TRANSPORT ASSESSMENT ADDENDUM

Project:	Land off Ploughley Road, Ambrosden, Oxfordshire – 22/02866/OUT	Page 1 of 6
Subject:	Site Access Arrangements	Date: 10/01/2023

Technical Note Prepared by:	Approved for Issue by:
Christopher Miles Transport Consultant	Max Thurgood Director

PROPOSED CYCLE ACCESS  
SCALE 1:100

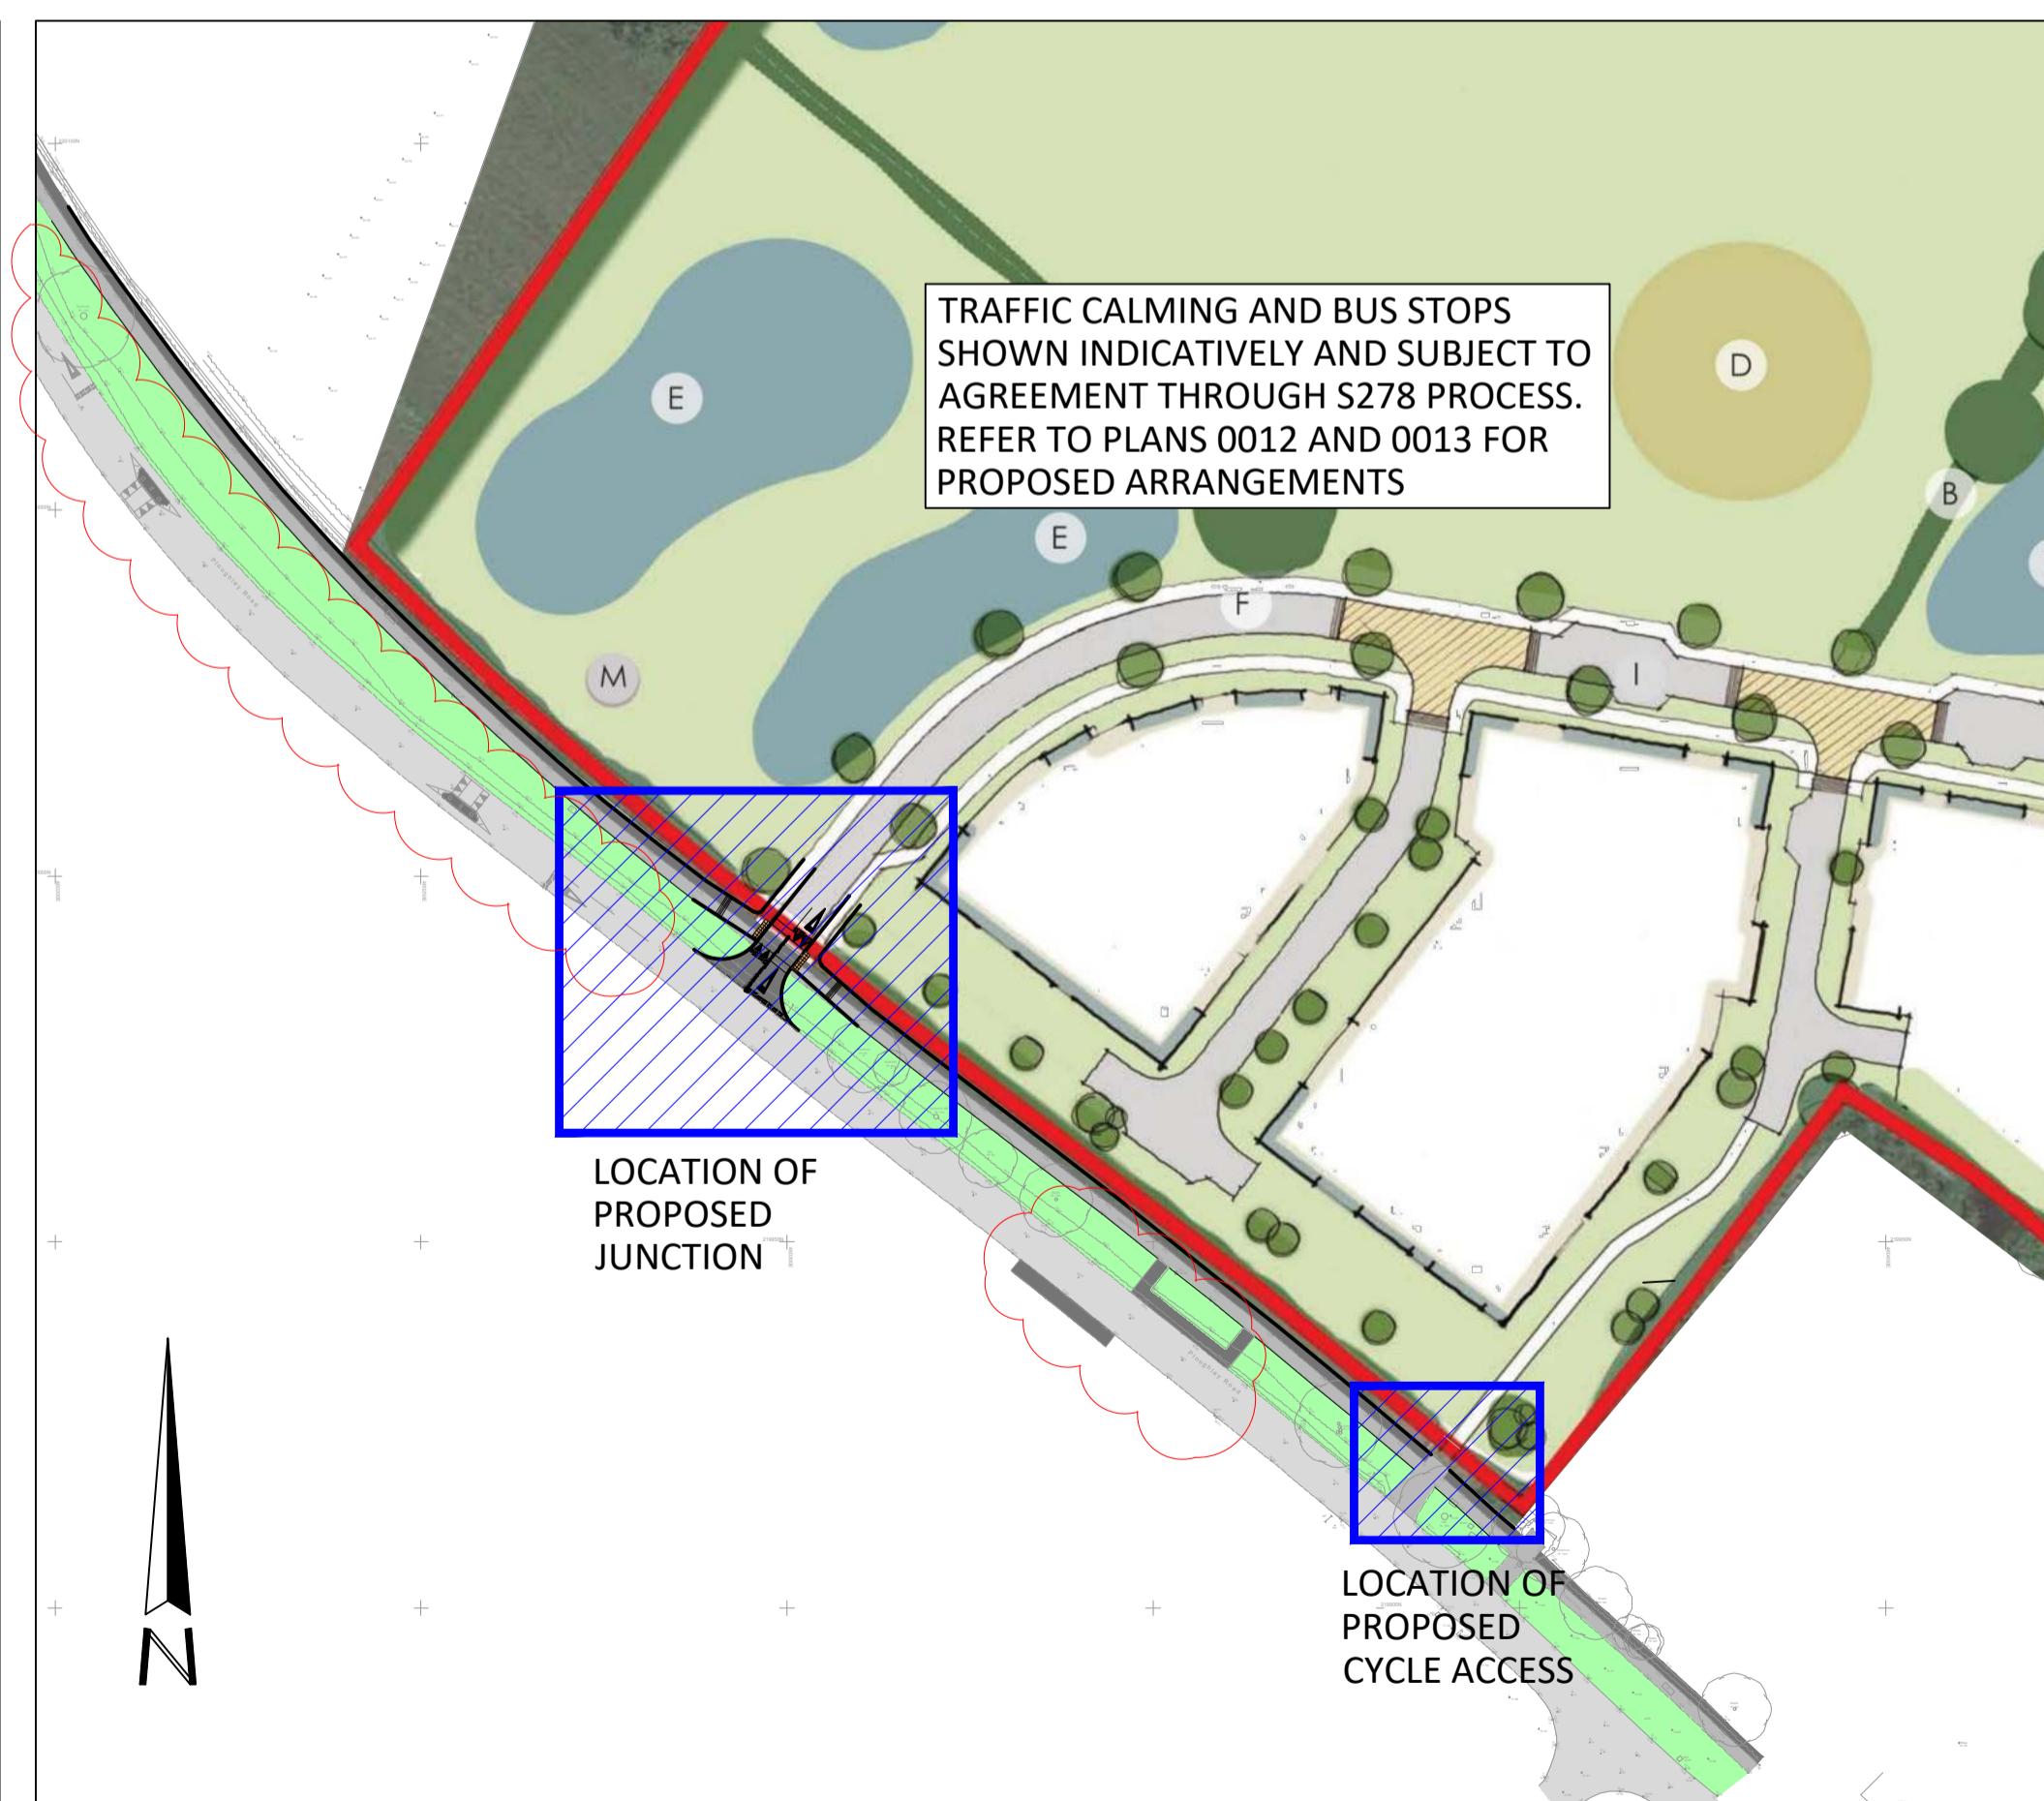
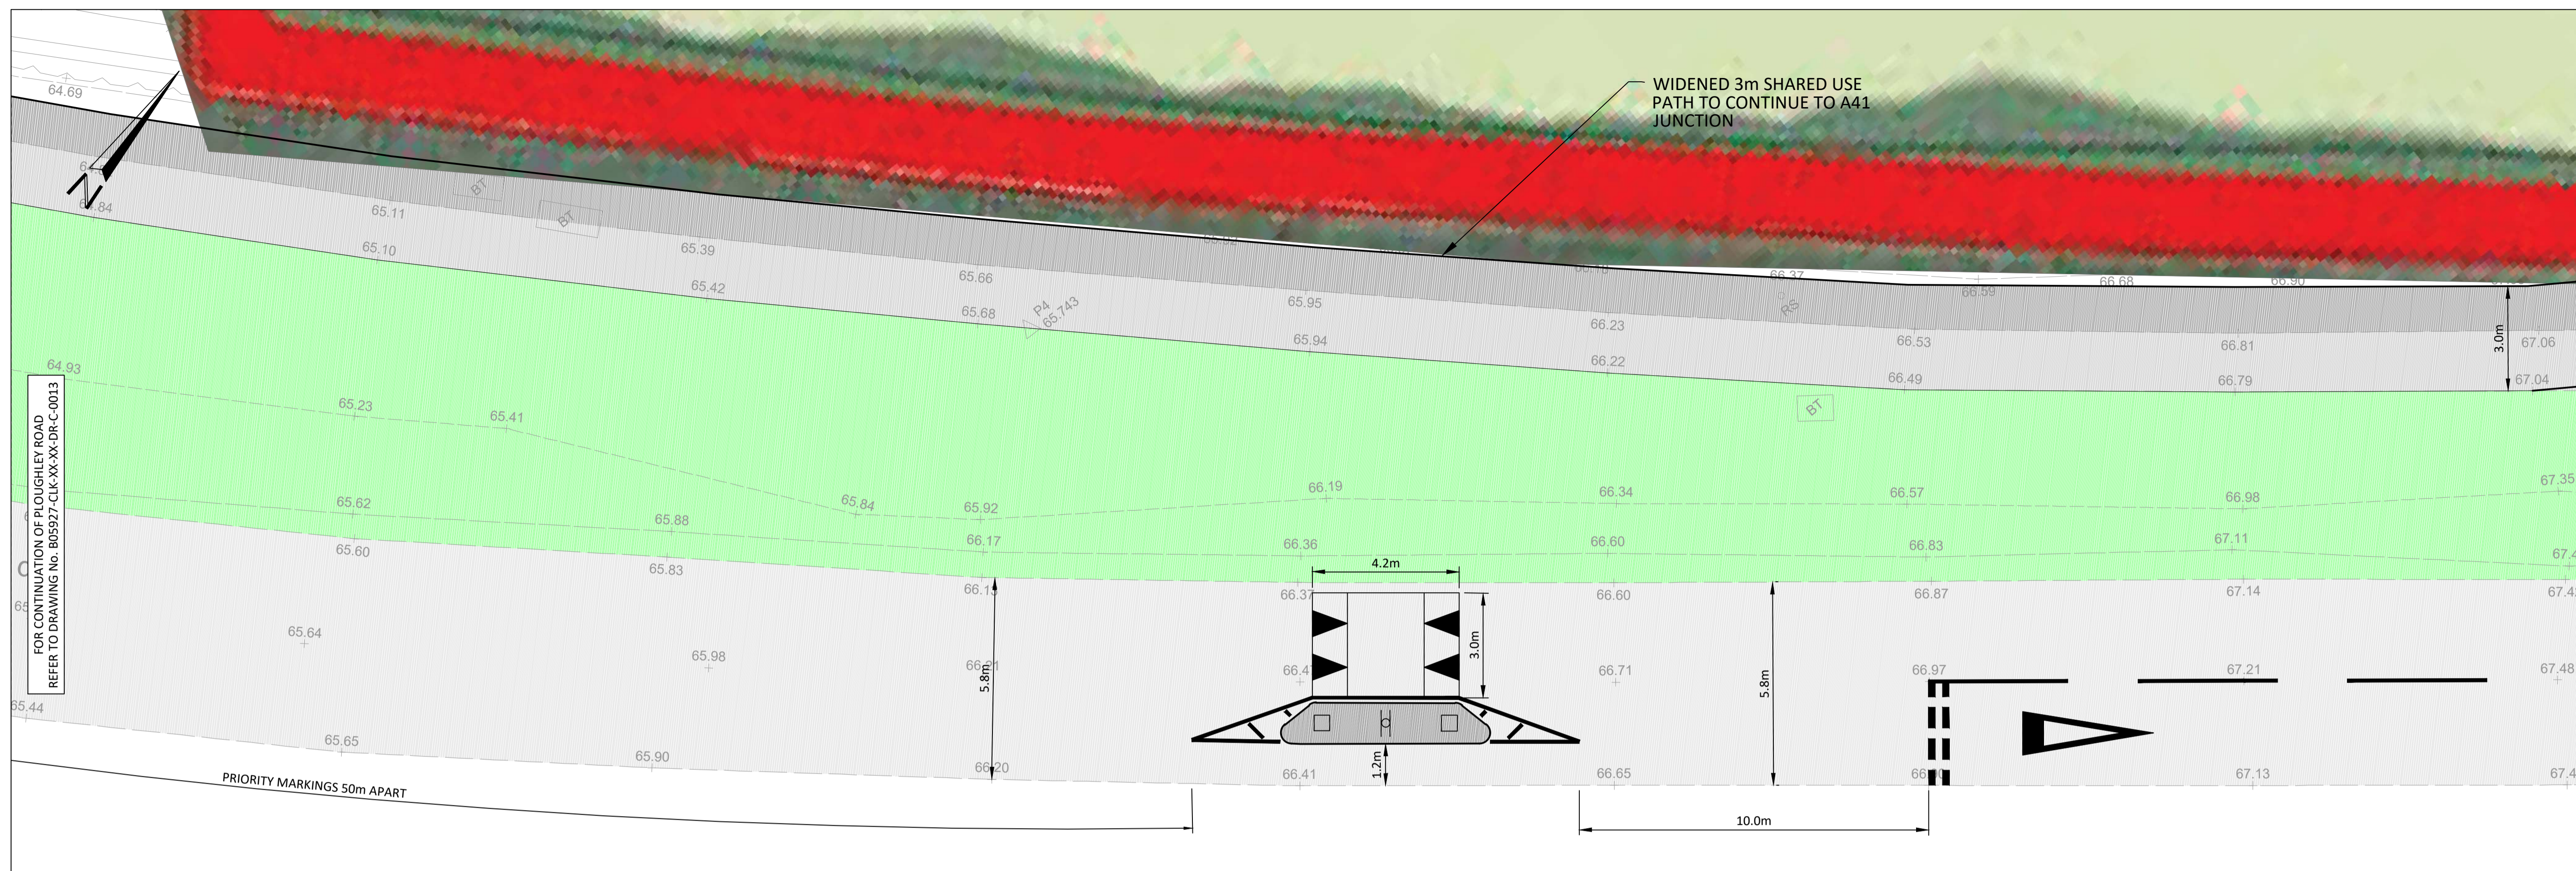
The OCC consultation response also identifies that the bellmouth access junction must include a cycletrack crossing in accordance with Local Transport Note 1/20: Cycle Infrastructure Design. The layout of the access junction has therefore been amended to give greater priority to the existing shared use path where it crosses the proposed site access (plan 0007_P06 in Appendix B).

The path is shown as being widened to 3m where it crosses the access road and slightly realigned into the site to increase the offset distance from the Ploughley Road kerb line to approximately 6m. This in turn allows the introduction of a raised table to give pedestrians and cyclists using the shared use path priority over vehicles entering and departing the residential development. This can also be reinforced through the provision of formal ‘give way’ road markings on the site access.

This arrangement complies fully with the LTN1/20 design guidance including the provision of appropriate car driver to cycle path visibility splays in both directions.
